To: Lindsey Stuart (East Lindsey District Council)
From: Royal HaskoningDHV
Date: 08 April 2024
Copy: Job File
Our reference: PC3999-WM-ME-240402-1420
Classification: Project related
Checked by: Paul Salmon

Subject: Viking CCS Pipeline Environmental Impact Assessment Report Review

Royal HaskoningDHV has been commissioned by East Lindsey District Council (ELDC) to review selected elements of the Environmental Statement (ES) on their behalf pertaining to the Development Consent Order (DCO) application for the Viking CCS Pipeline project by Chrysaor Production (UK) Limited.

6.9.3 Waterbodies in a River Basin Management Plan

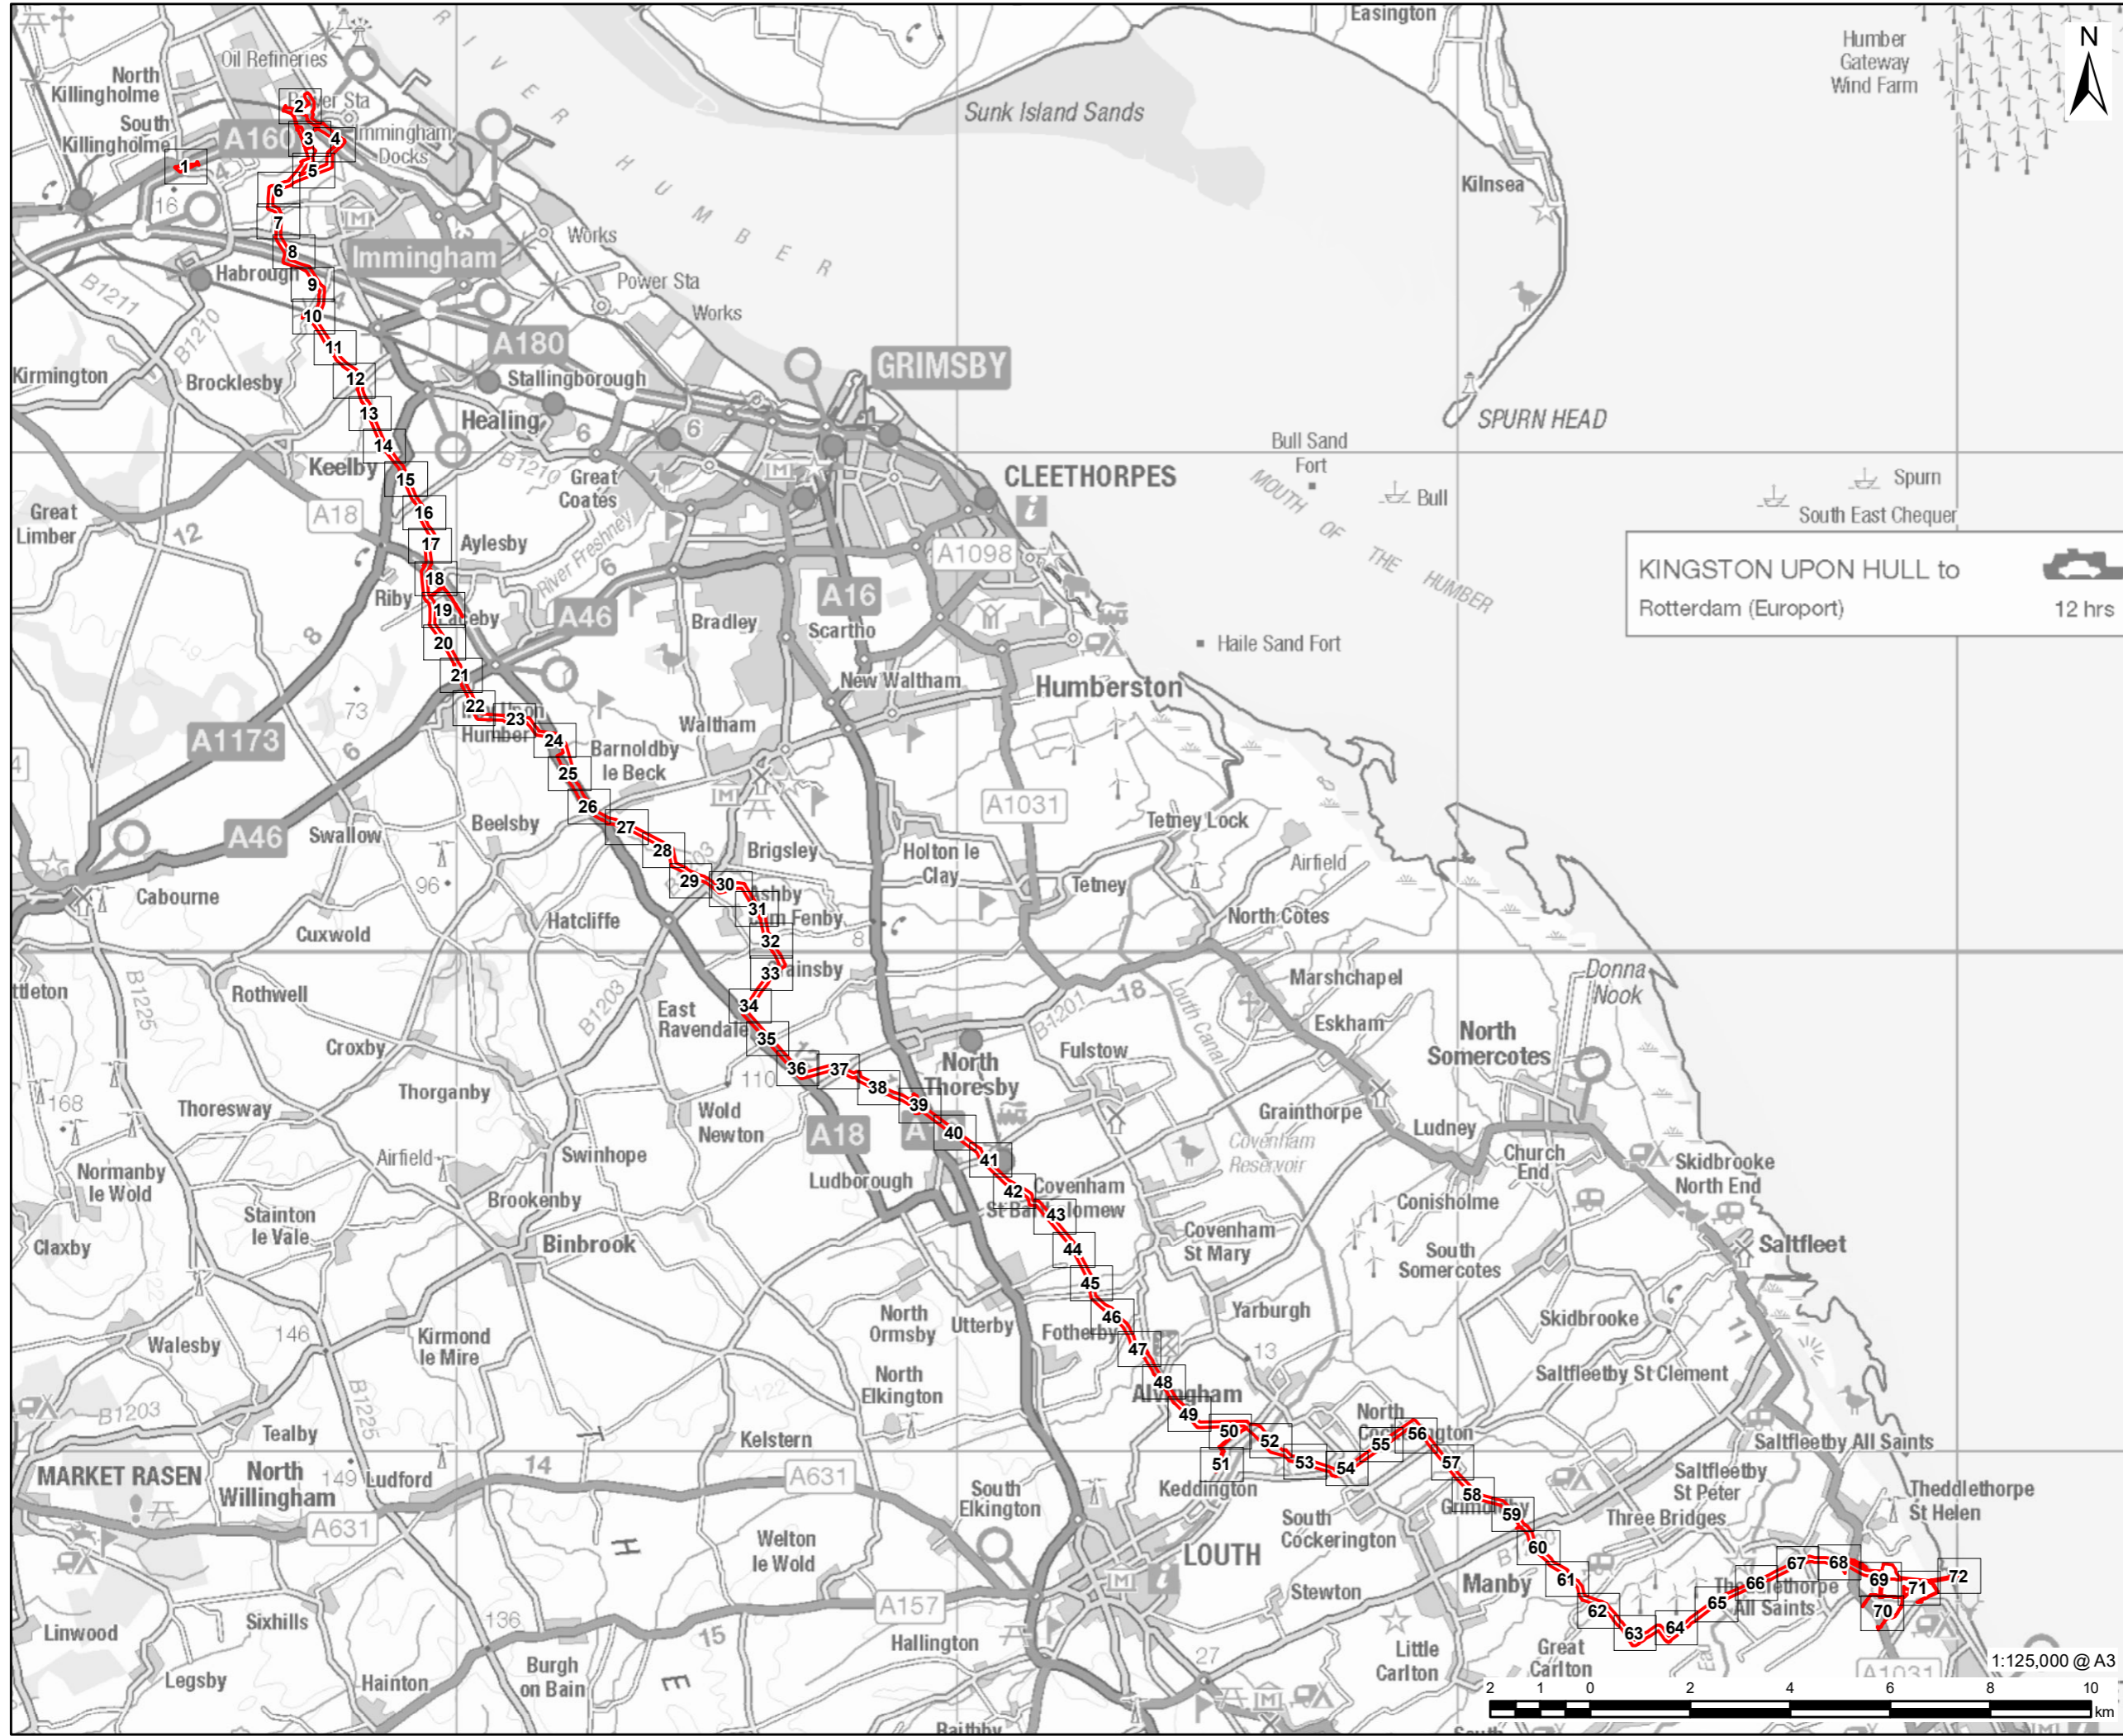
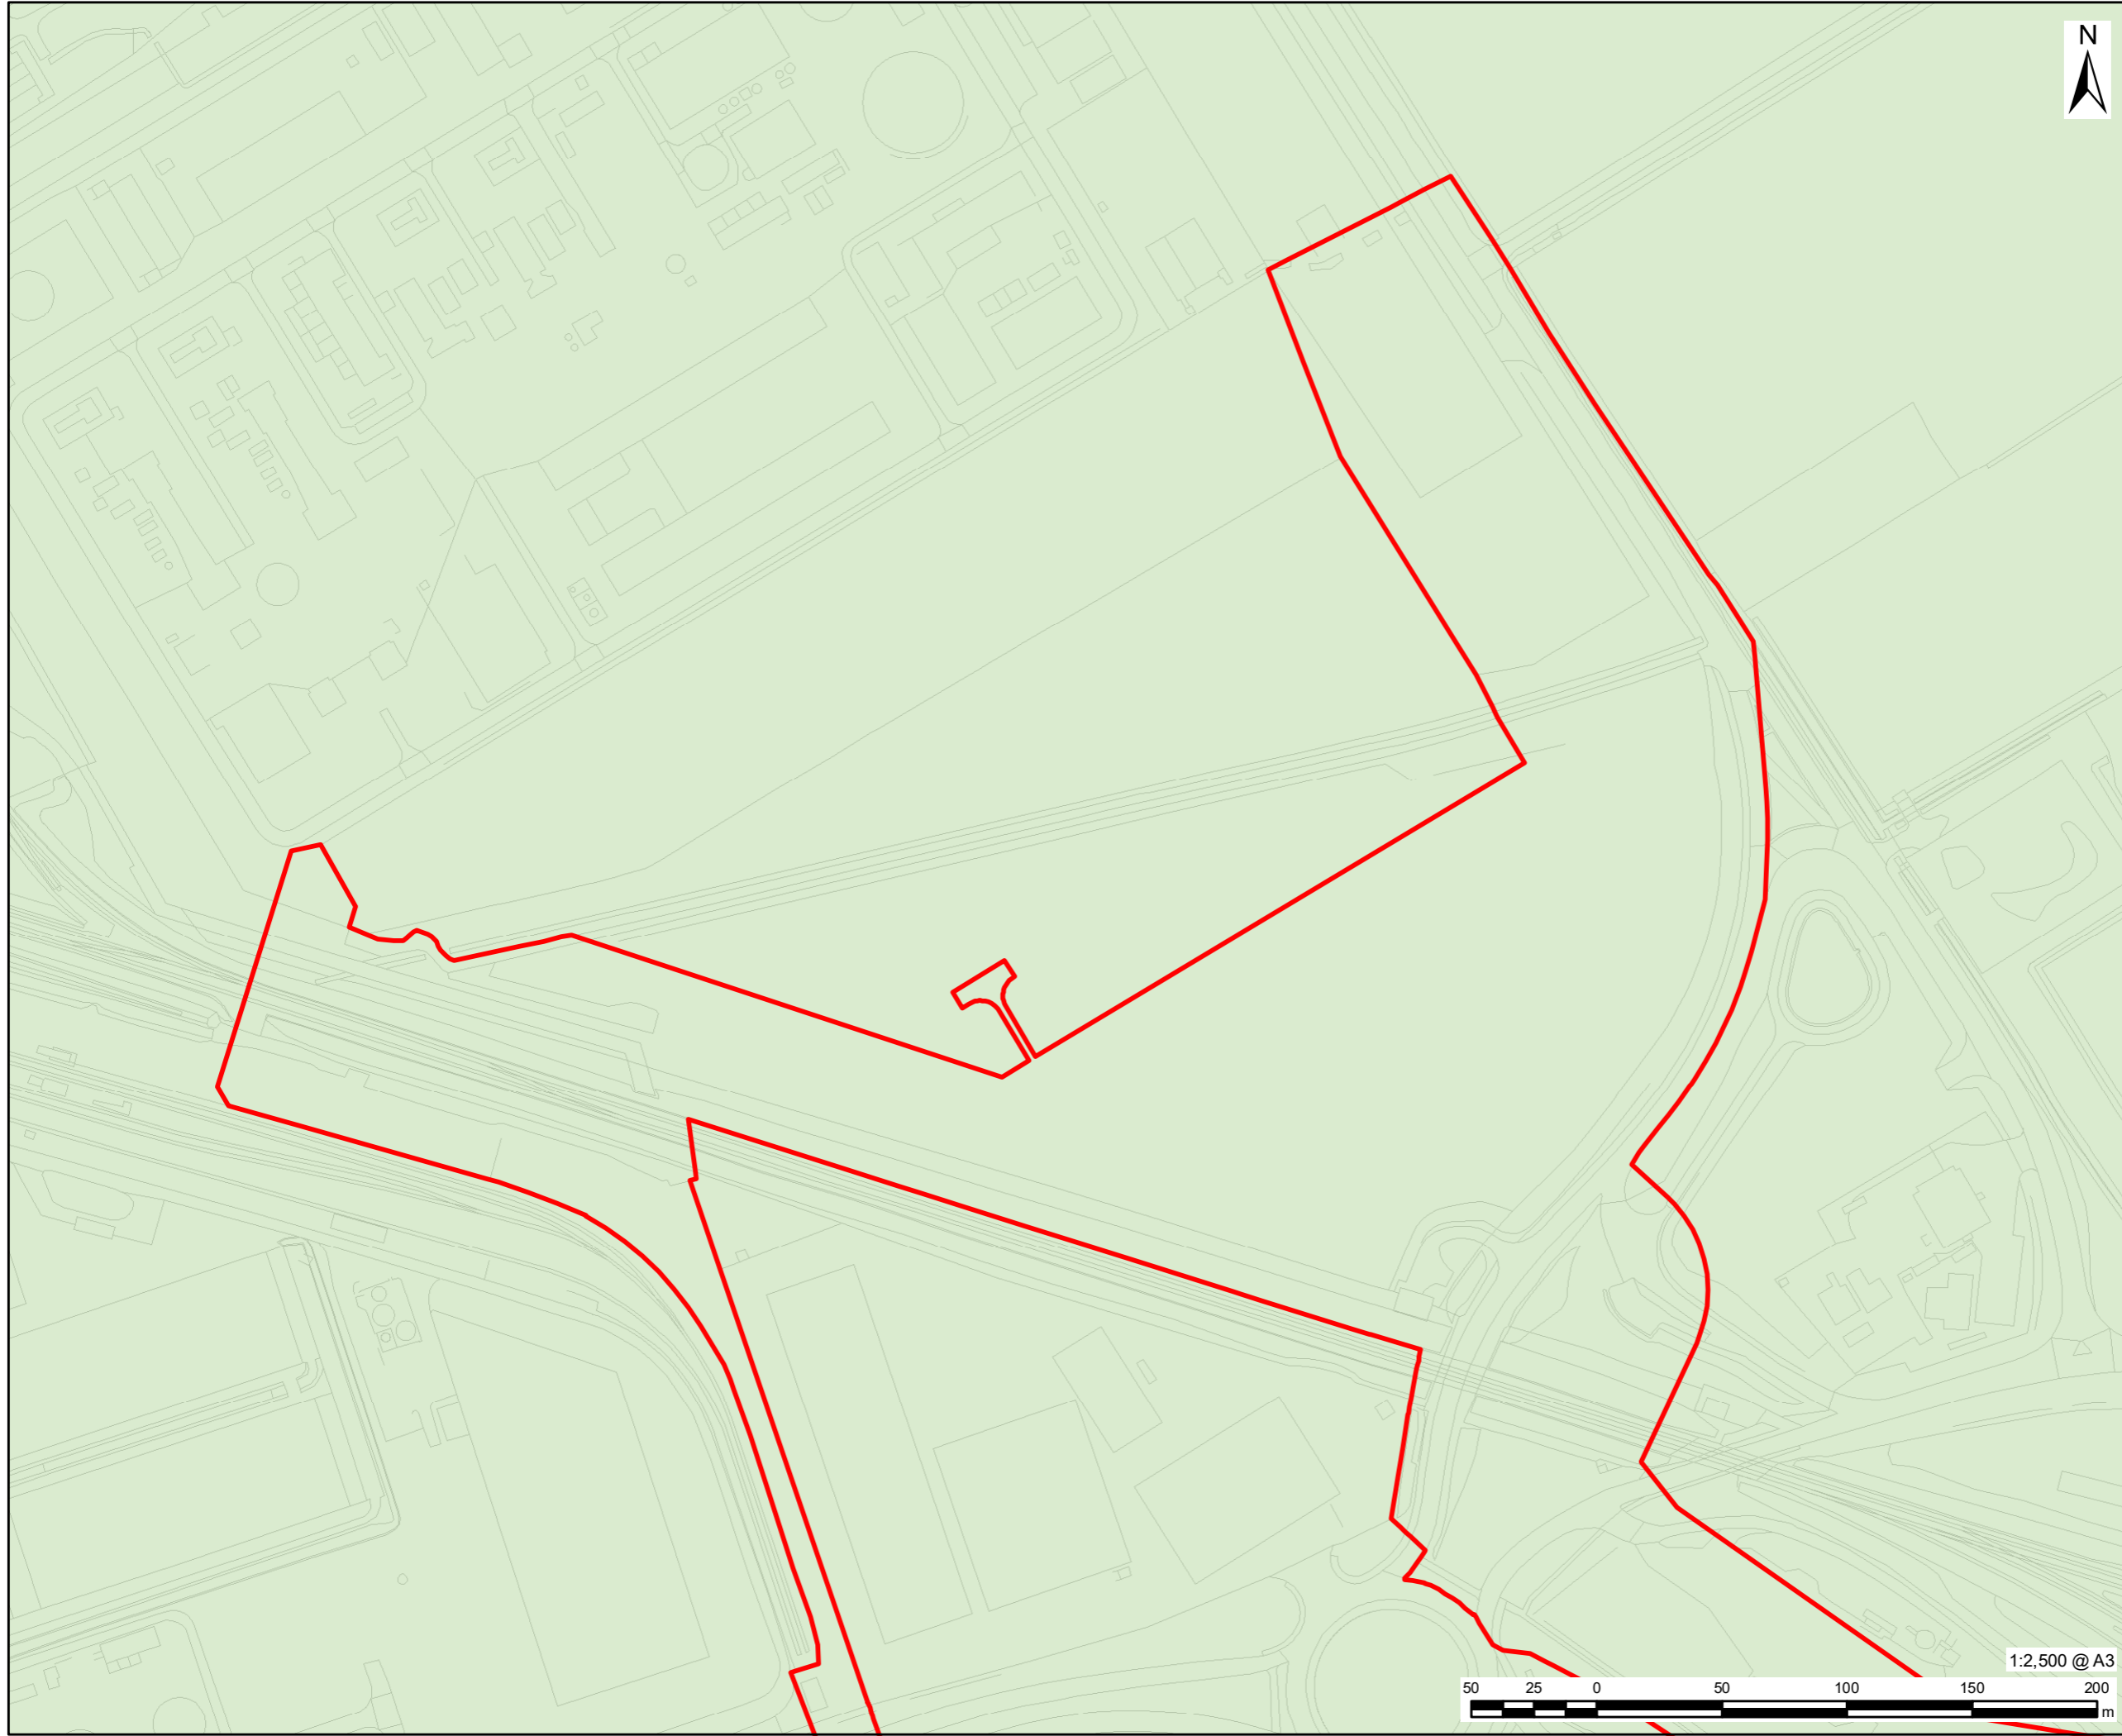
- With regards to Table 11-10 'WFD Study Waterbody Status within study area of the DCO Site Boundary (Cycle 3)', updates are required in order to show the latest 2022 status updates for Cycle 3 as the table currently contains data from 2019.
